**From:** Finlay Gardner <Finlay.Gardner@arun.gov.uk>  
**Sent:** 04 March 2020 11:36  
**To:** Planning.Responses <Planning.Responses@arun.gov.uk>  
**Subject:** FW: LU/370/19/PL

Existing Ground Floor Plan
(1:100)

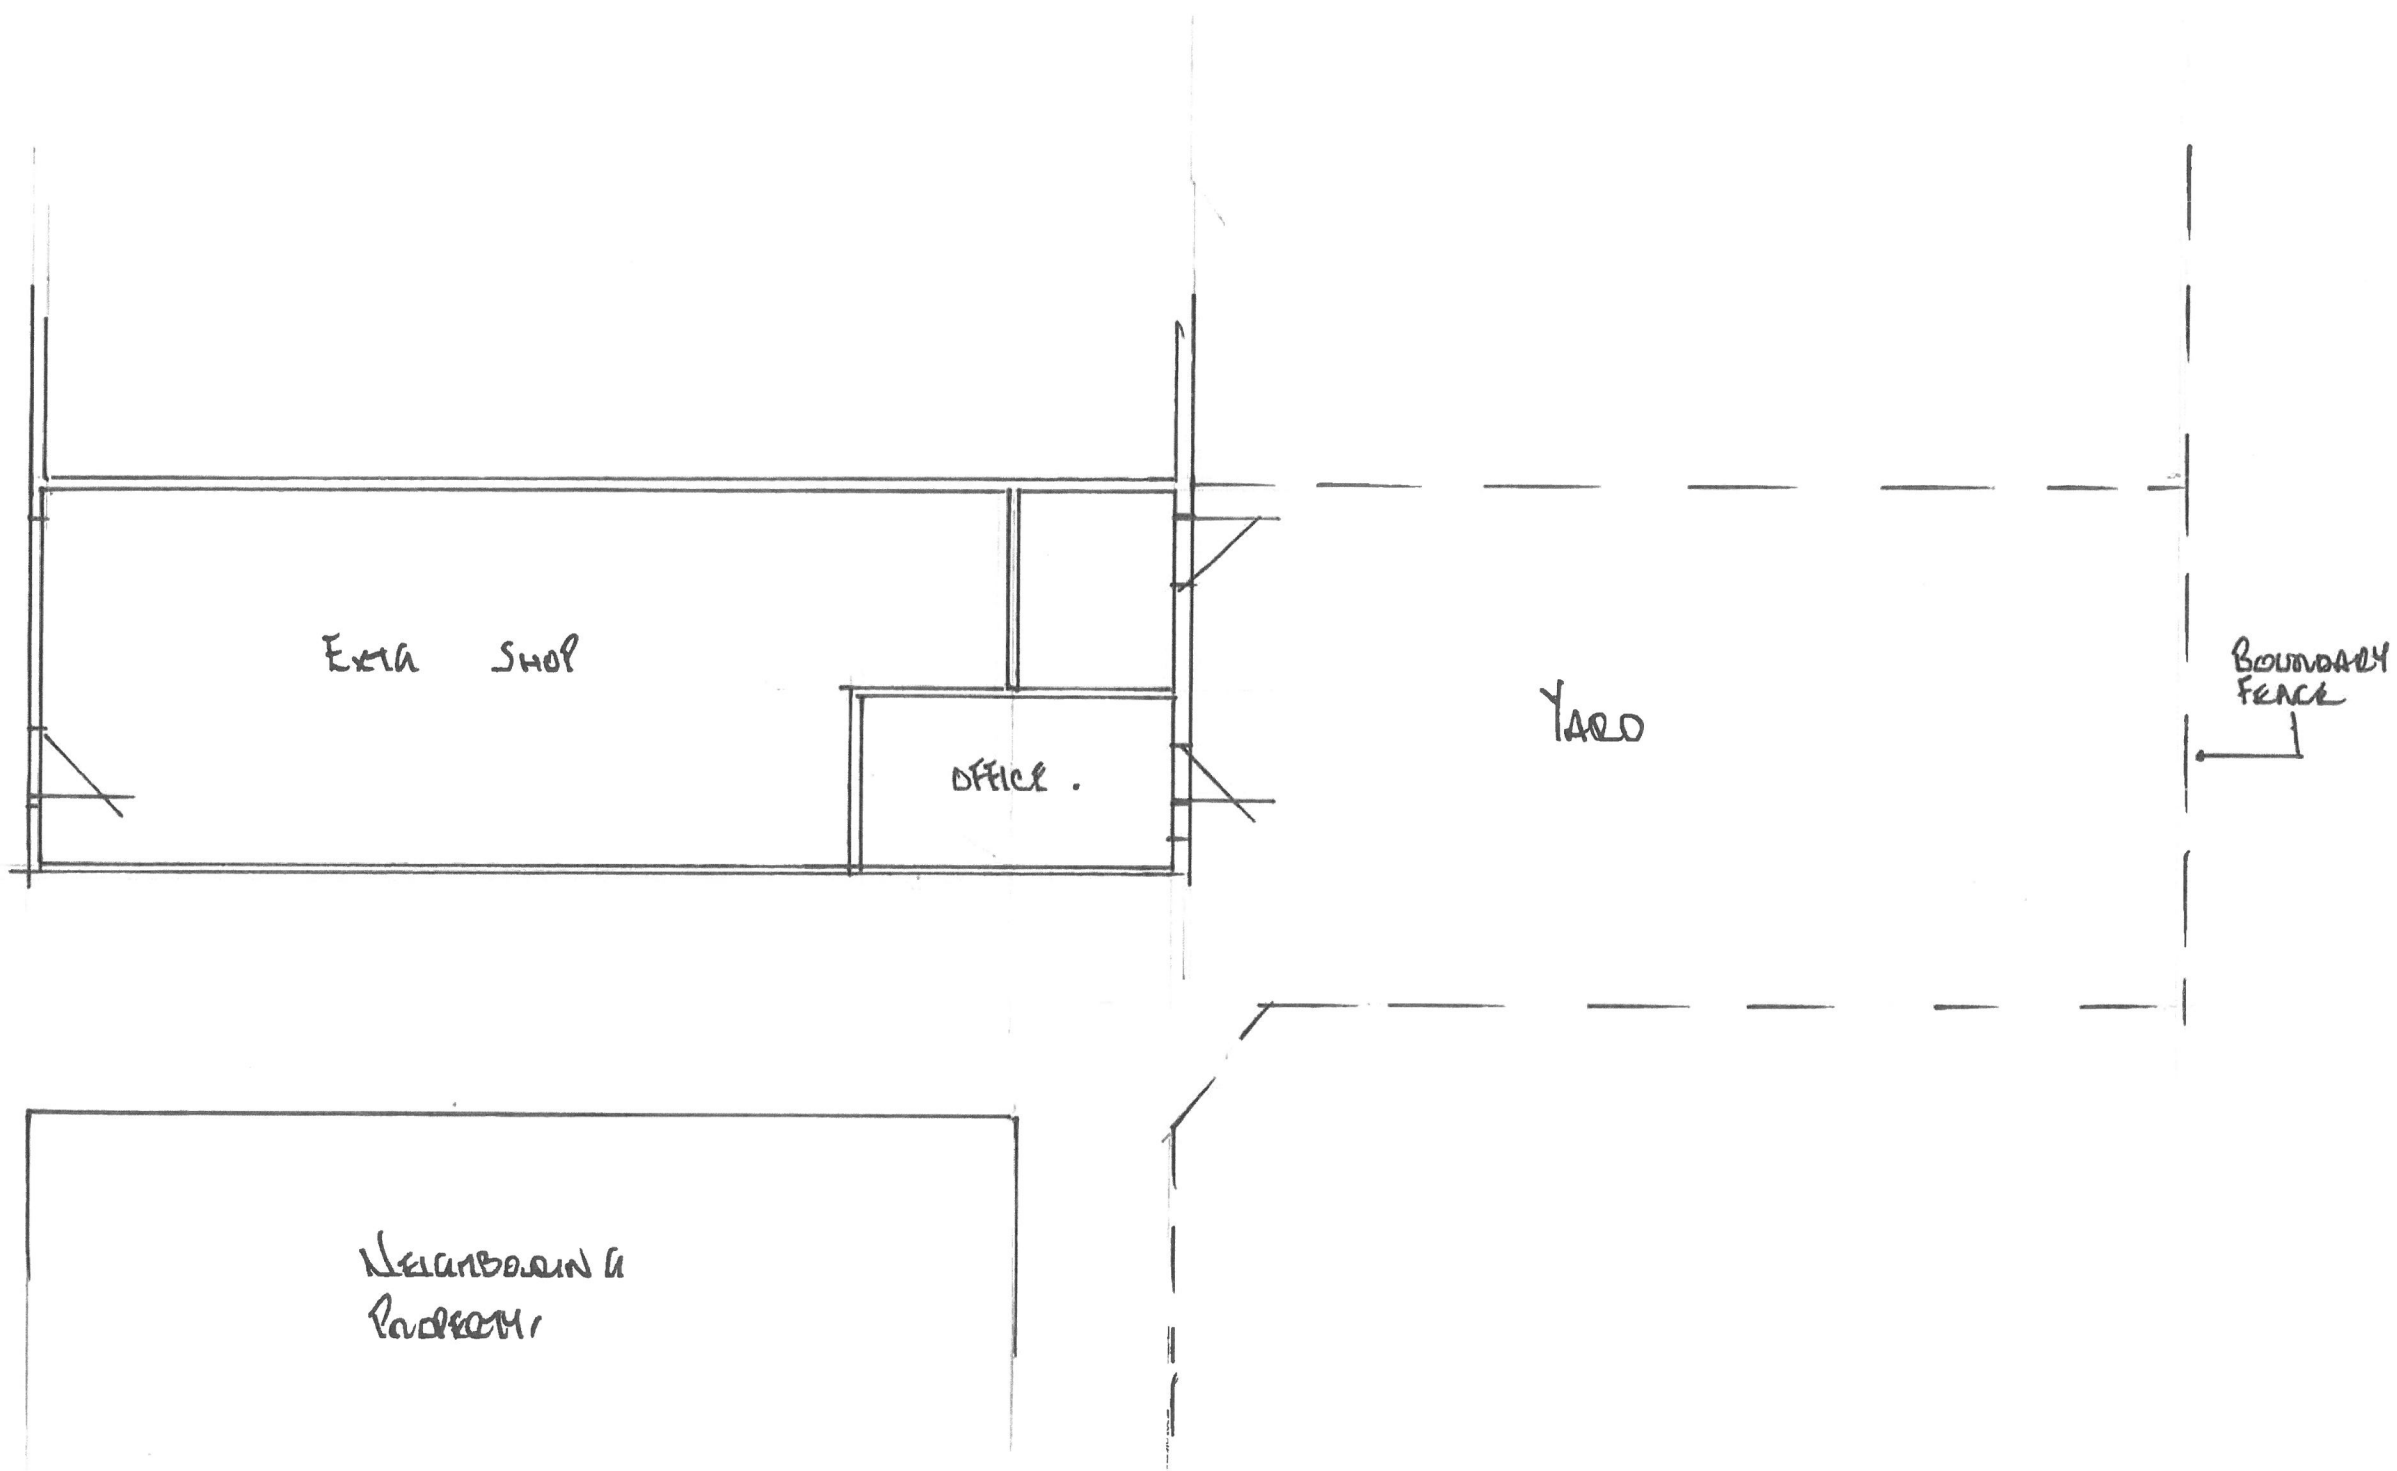
**On the Existing Ground Floor Plan:**

- The existing stair case needs to be added to the plan.
- There needs to be some clarification to the other unlabelled room. rear exit lobby, it splits the shop from rear door for security measures. It's only a temporary simple stud work. Is this a store room and does this have an internal access to the shop? Yes it has access to the shop area

PROPOSED GROUND FLOOR PLAN.
(1:100)

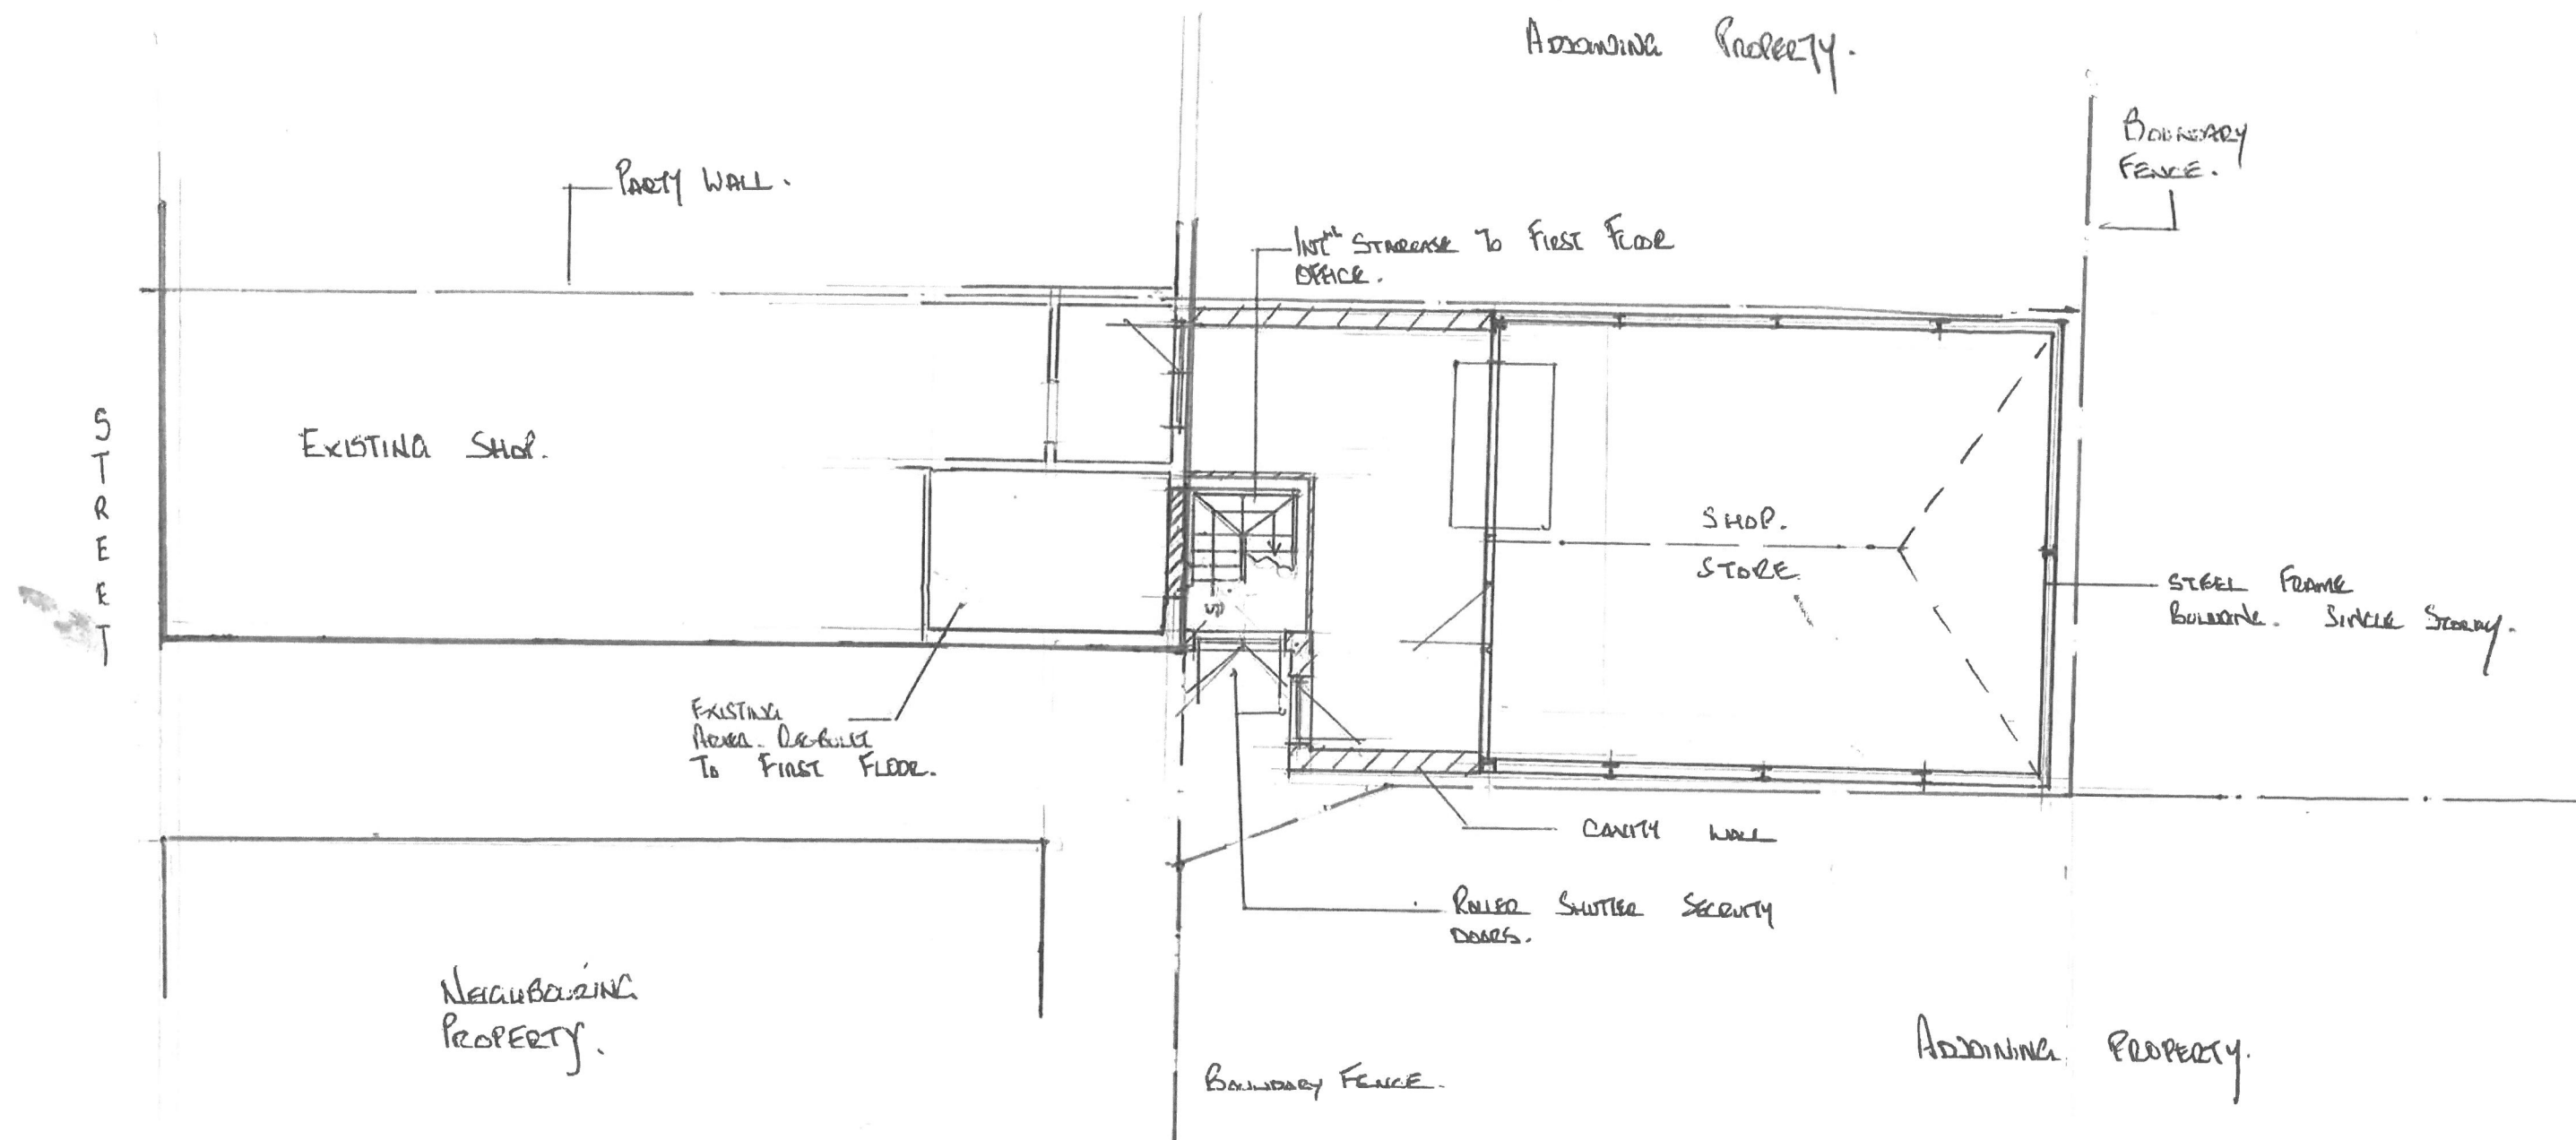
**On the Ground Floor Plan as Proposed :**

- The internal staircase to the first floor needs to be clarified as to whether it connects to the office in the first floor or the flat. It opens onto the open flat roof area. The additional office is accessed from within the flat
- There also needs to be clarification regarding the security doors or roller shutter. If it is a roller shutter this needs to be shown on the elevations rather than the doors. Both openings have doors and additional roller security shutters.

[1:100]
[As Proposed.]

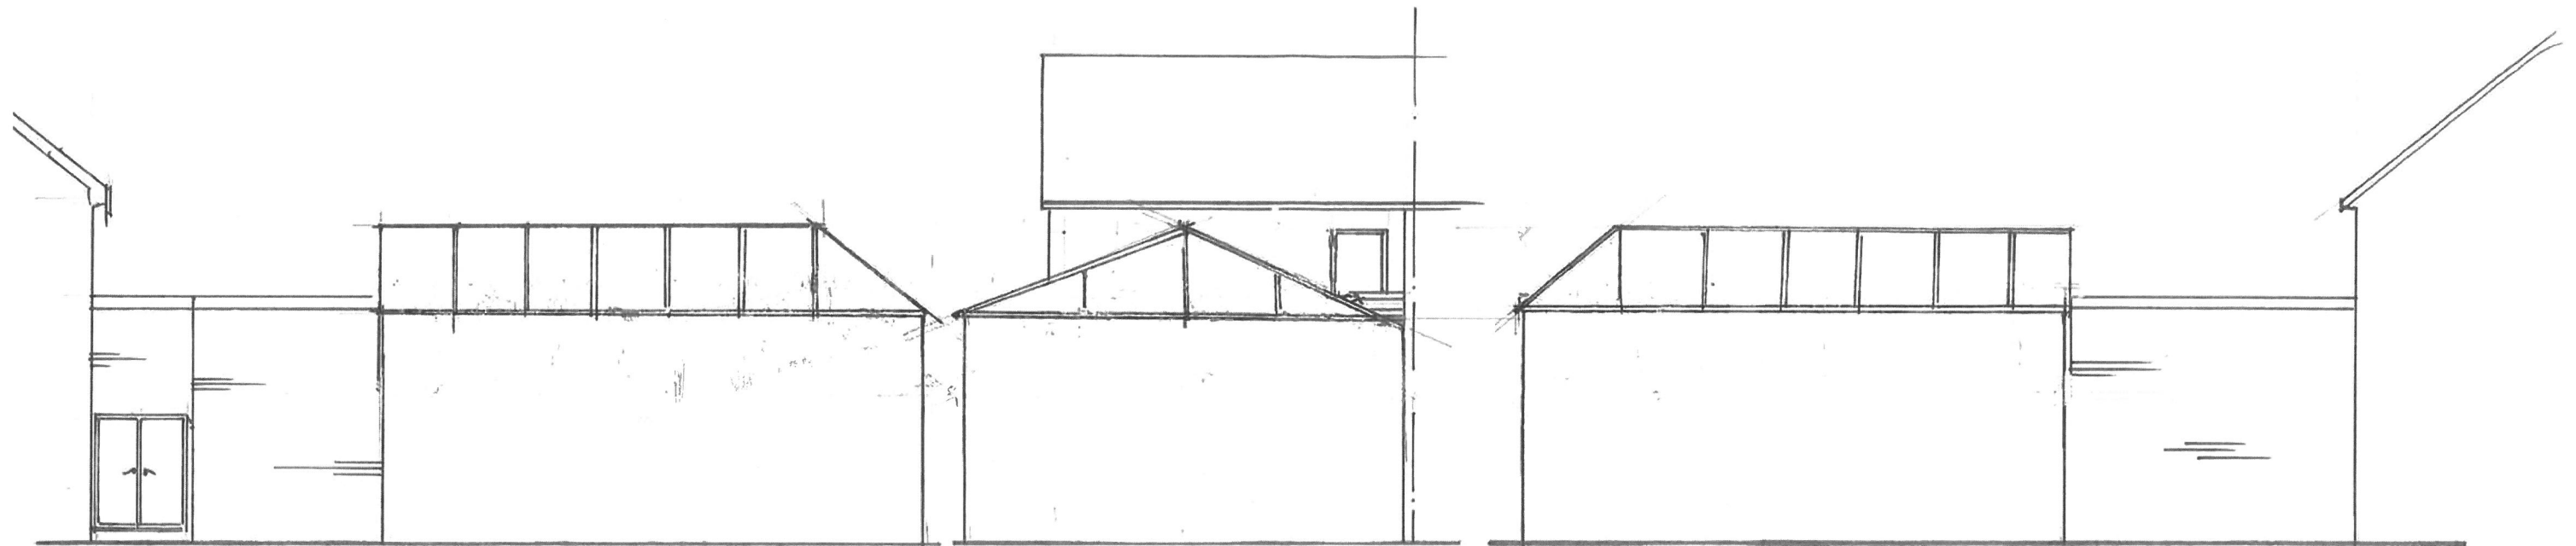
**On the Proposed Elevations:**

- The depth of the wall at the first floor needs a dimension or measurement with the dotted line to show the floor level. We would rather it be a enclosed fence, due to the 'right to light' criteria, we know it is not part of planning, but we have to be sympathetic to neighbours, and do not want it to be imposing like other buildings we have seen.

NORTH ELEVATION WEST ELEVATION SOUTH ELEVATION

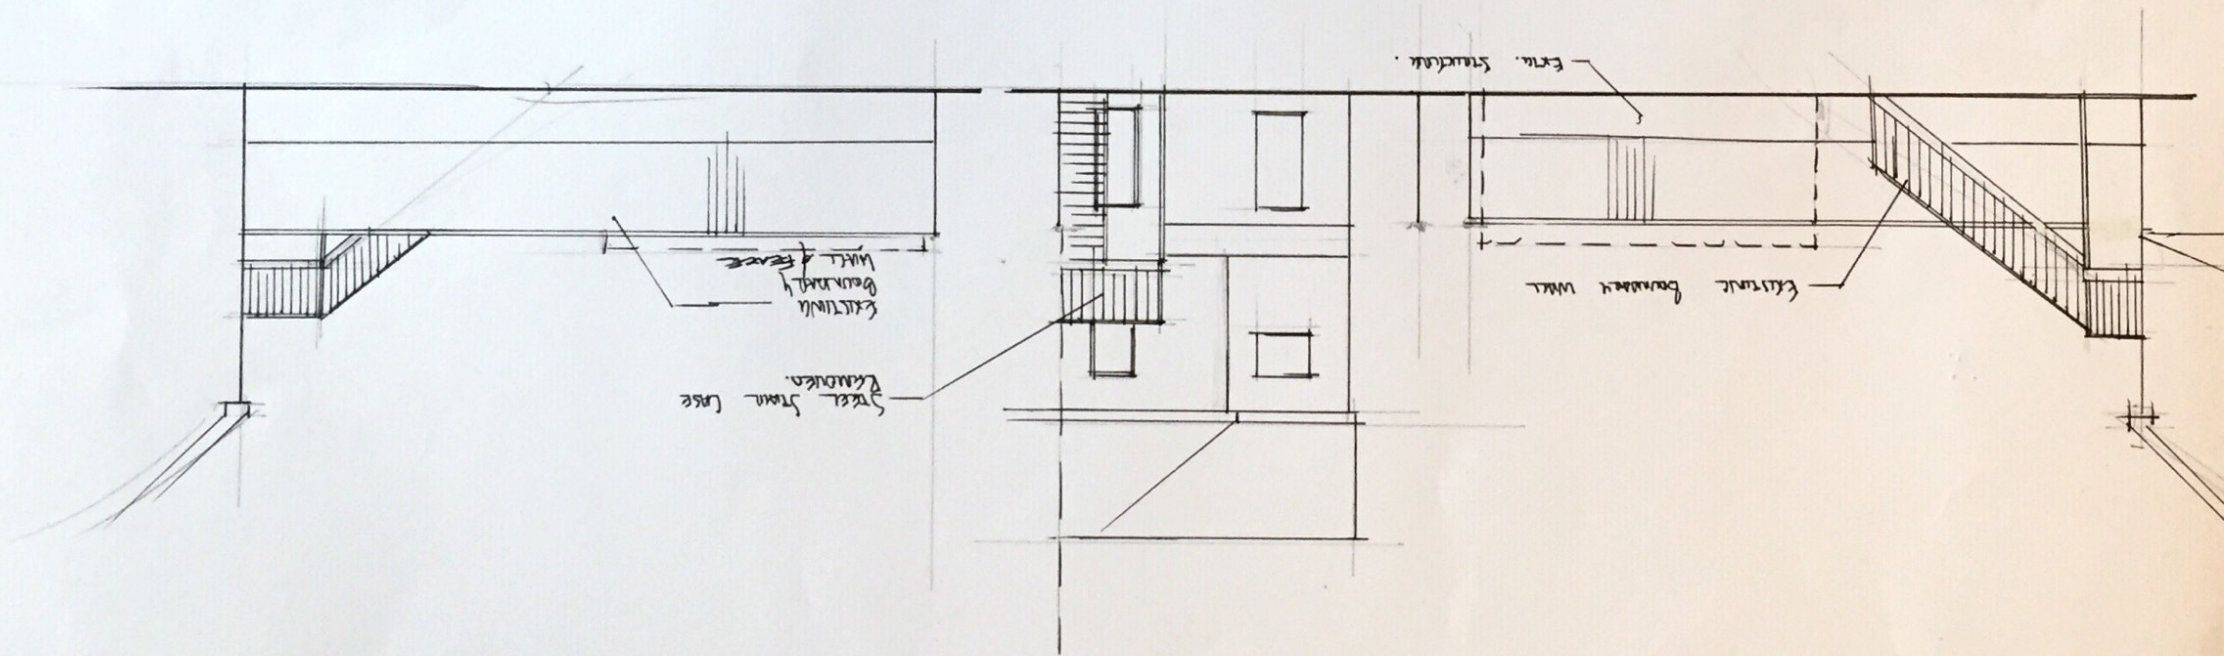
**On the Existing Elevations:**

- The existing south elevation shows a boundary wall it is not, it is a fence that is stepped in height this needs to be shown and labelled correctly. There is a wall approx 800 high and then a fence above this. The rear wall (west) is a wall with a fence on top the same.
- The existing structure is not on the west, north or south elevation plans.
- The northern and western elevations do not represent the site with an existing sloping roof single storey extension missing and the incorrect boundary treatment. This is not any extension, it is the original building. It houses the original outside toilet, and incoming utilities
